Date: 1 June 2022
Our Ref: M21/0204-07 JR
Your Ref: 21/02083/REM

**RE: APPLICATION FOR APPROVAL OF RESERVED MATTERS 21/02083/REM
LAND AT TAPPERS FARM, OXFORD ROAD, BODICOTE**

I write to you on behalf of the Applicant, GreenSquare Homes, to submit a pack of further revised drawings for the above application for approval of reserved matters. These focussed revisions follow extensive discussions with yourself on the scheme design; most recently at a meeting on 27 April 2022 and subsequent correspondence on 14 and 16 May 2022.

REVISION/S:
 A. 2022-05-09. Unit to be brick-faced in lieu of stone. Cloakroom window moved to side elevation. Living Room window deepened. DJE

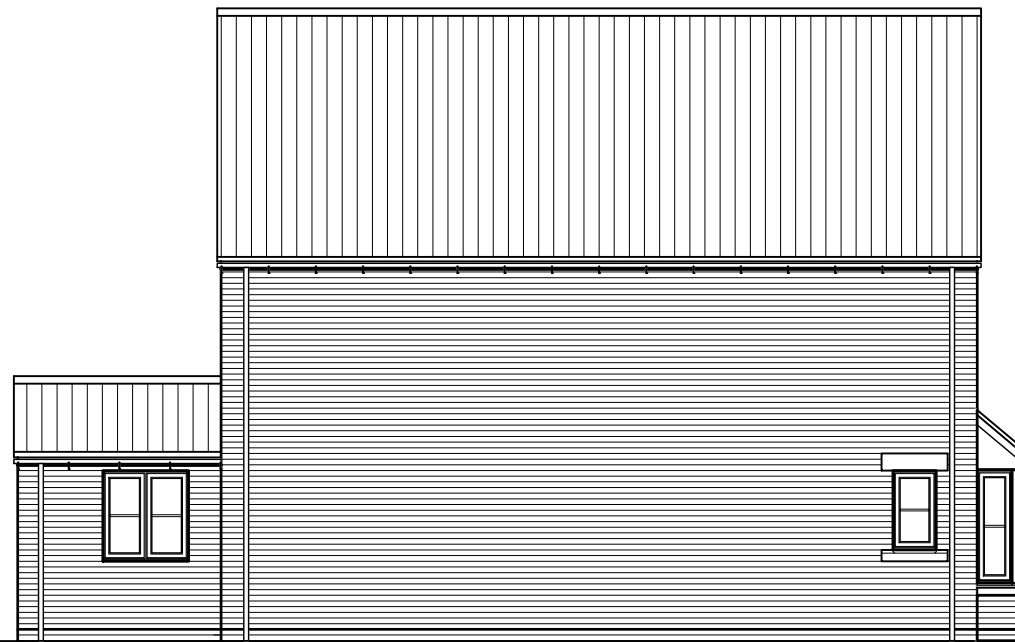
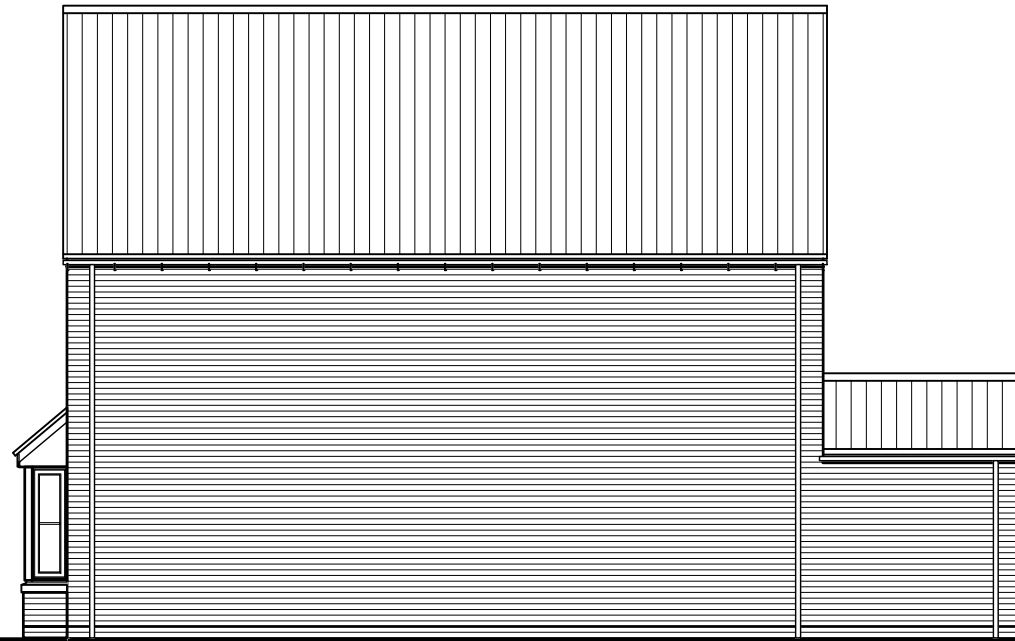
4. The proposed materials have been adjusted to reflect those recently approved on the nearby development north of Wykham Lane (reference 19/01037/REM) and to achieve a simpler, more cohesive character across the site. 30% of the proposed dwellings will be natural ironstone; these are located around the 'main street' and public open space to reinforce the 'gateway' character of this part of the site. All other dwellings will use a single specification of red stock brick.

REVISION/S:
 A. 2022-05-09. Plot 35 renumbered to 34. Plot 36 removed. Plot 46 handed. Kitchen replanned. Lounge and Dining Room windows deepened. DJE

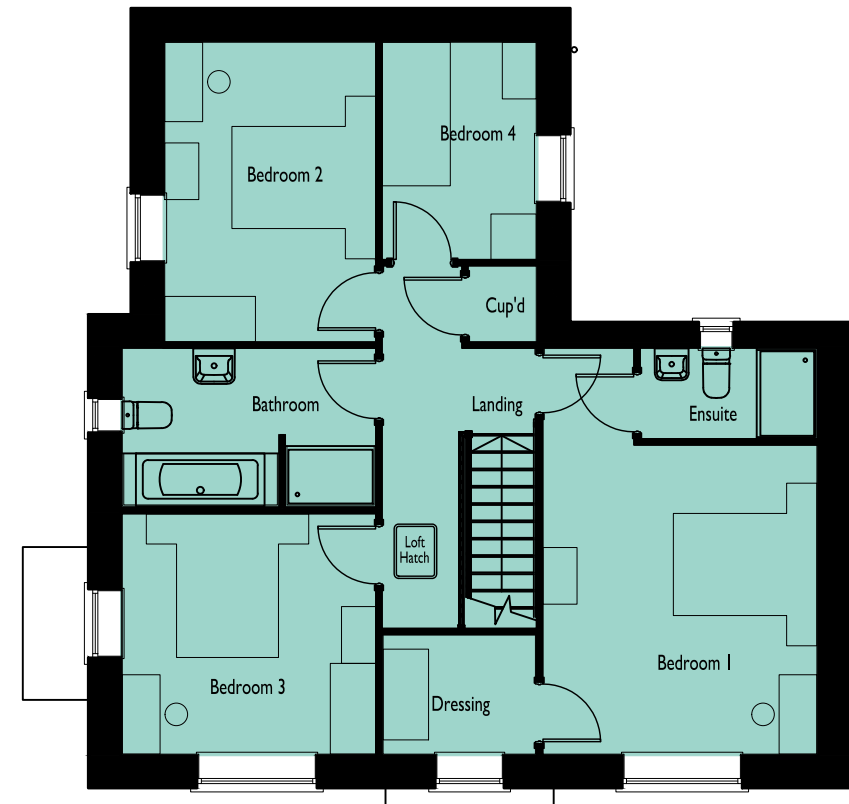
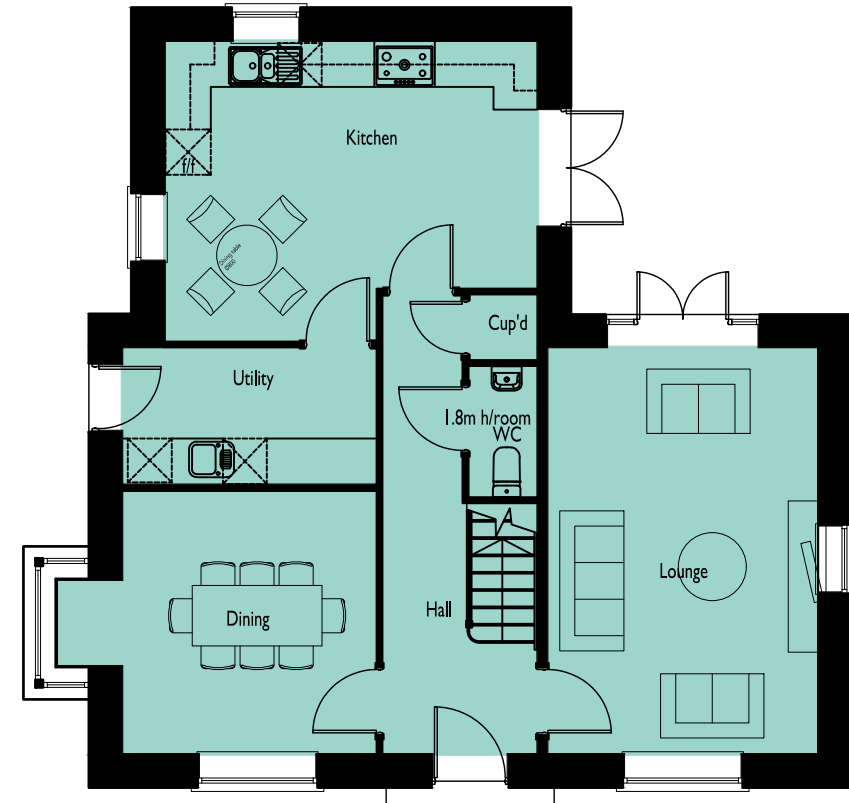
2. Plots 31 to 33 and 35 to 40 have been redesigned to form continuous terraces, creating a cohesive and attractive frontage to the 'main street' whilst reflecting the site's character as a 'gateway' to Bodicote.

LEGEND

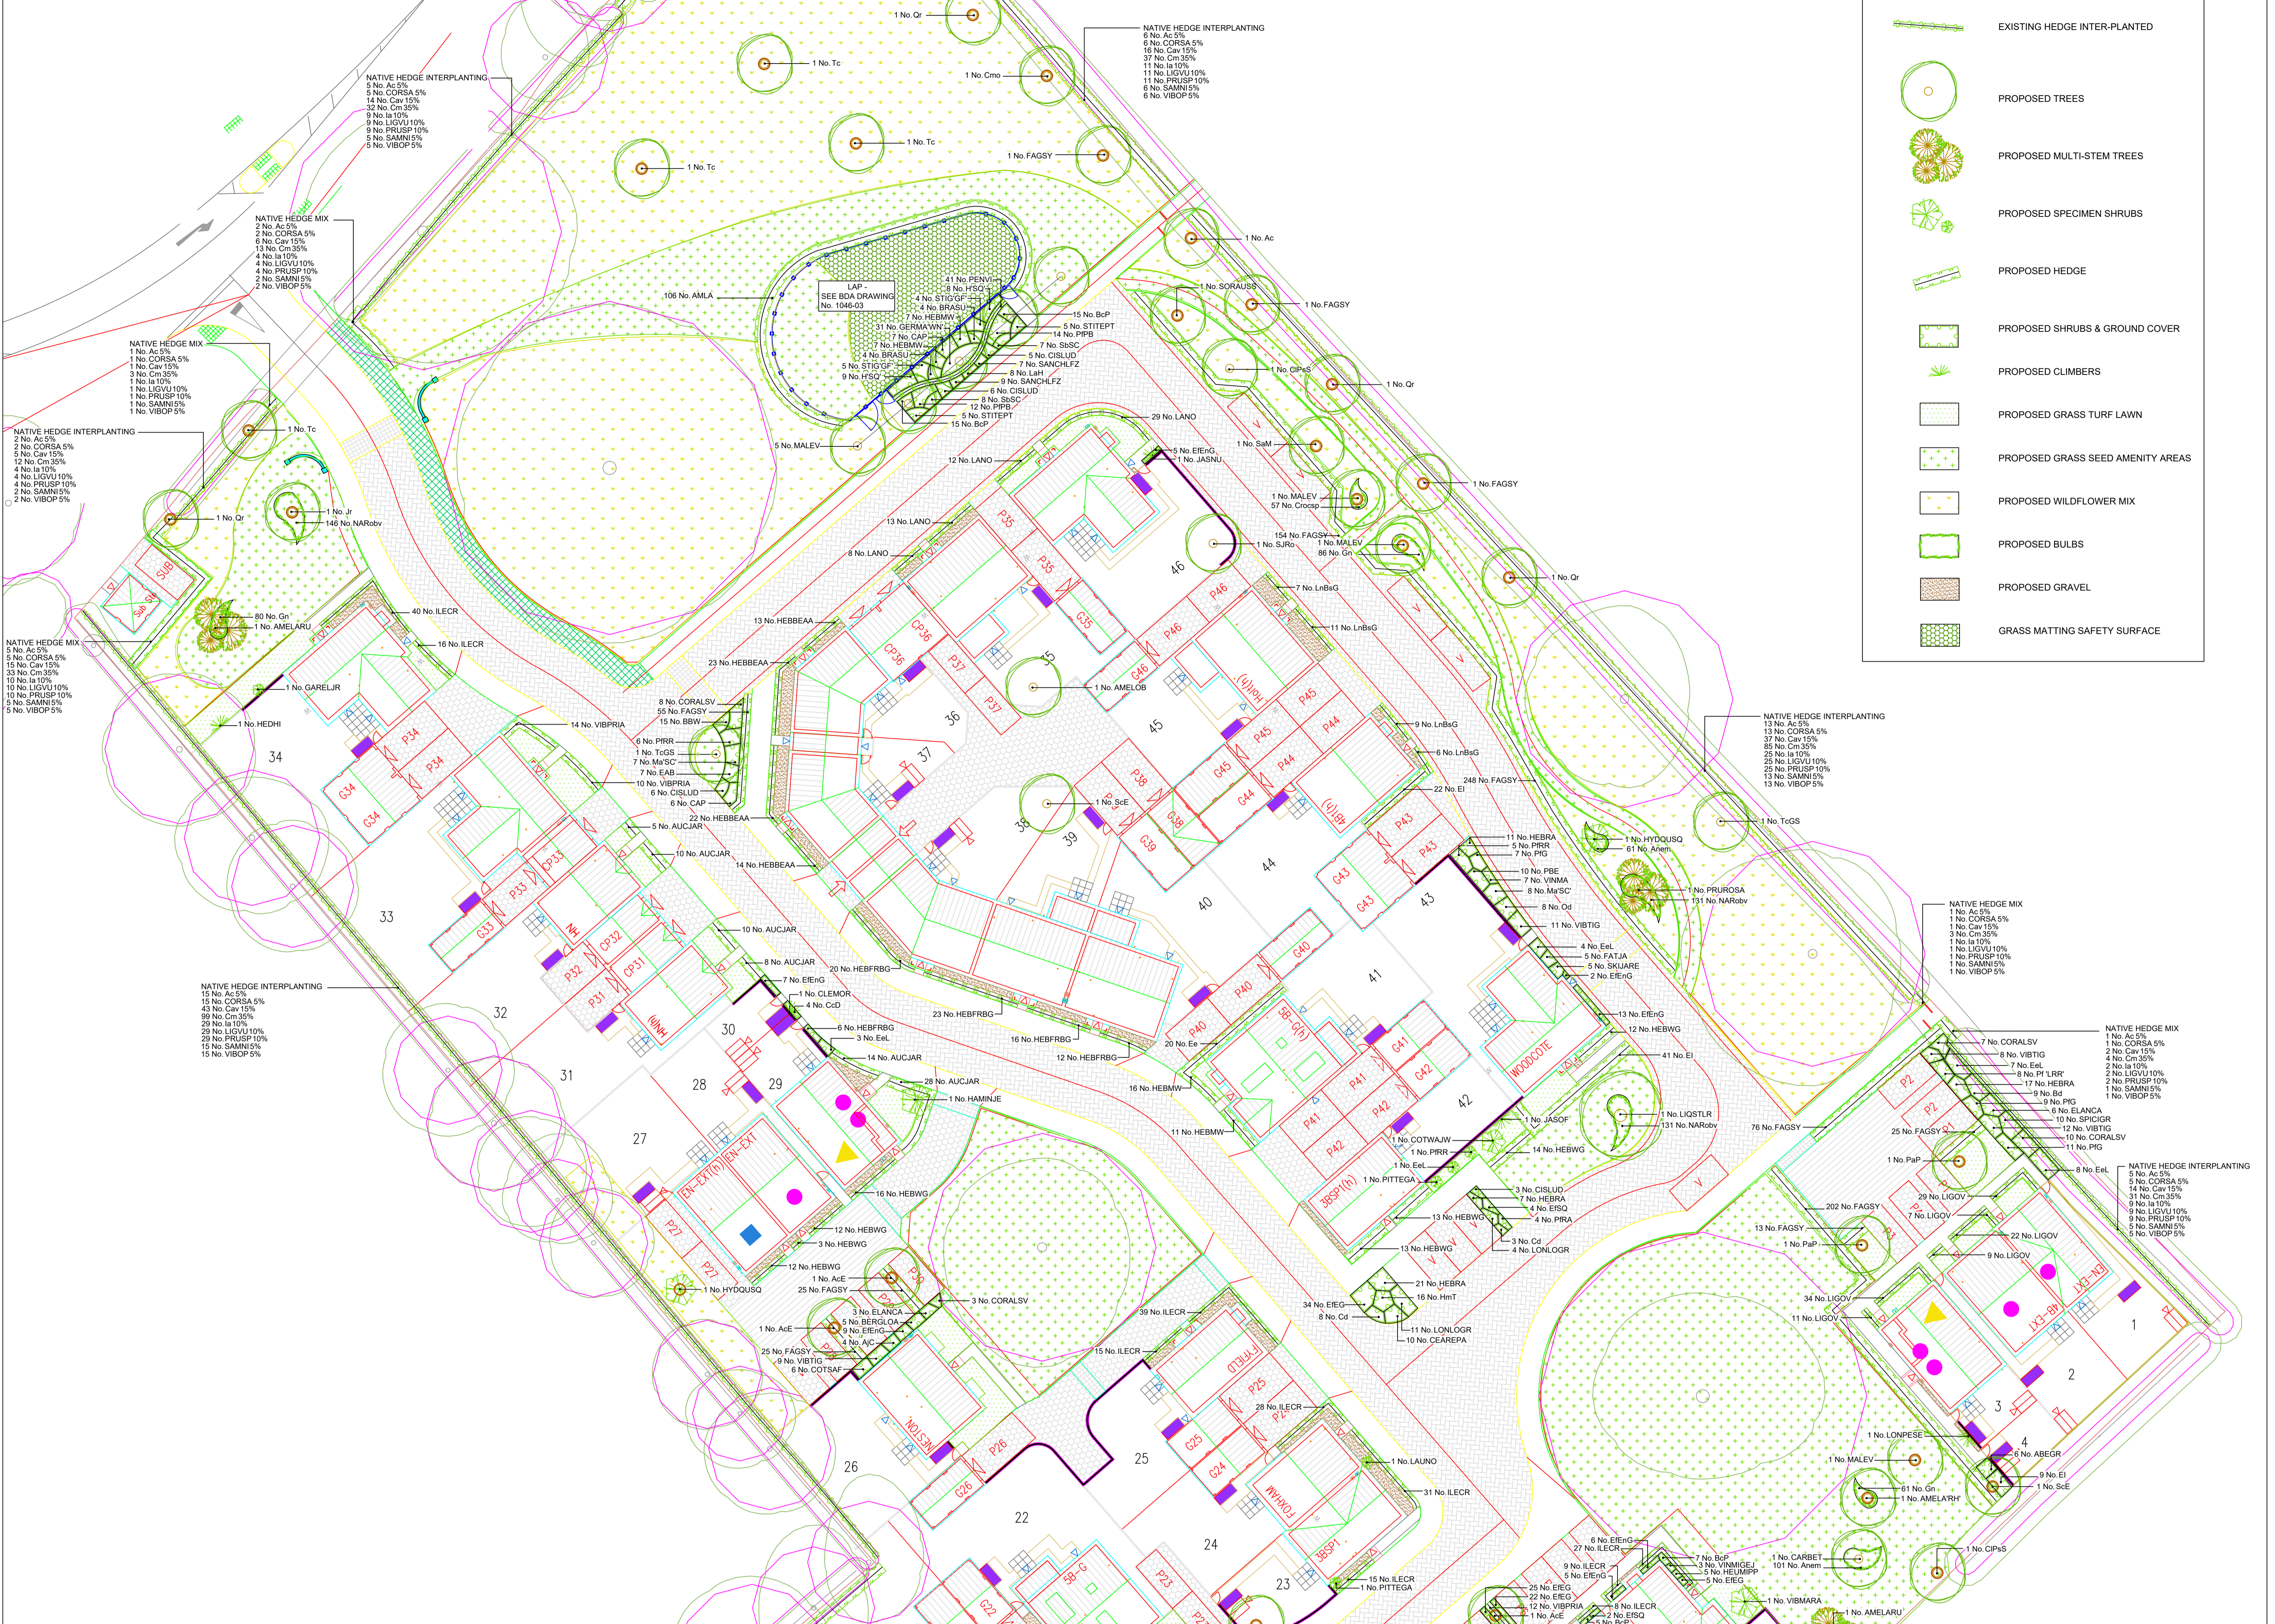
10. The revised Landscape Proposals and Play Area Proposals include additional detail to respond to the comments of the Landscape Officer.
11. The Noise Assessment, Street Lighting Design and Tree Survey have all been revised to reflect the latest scheme.
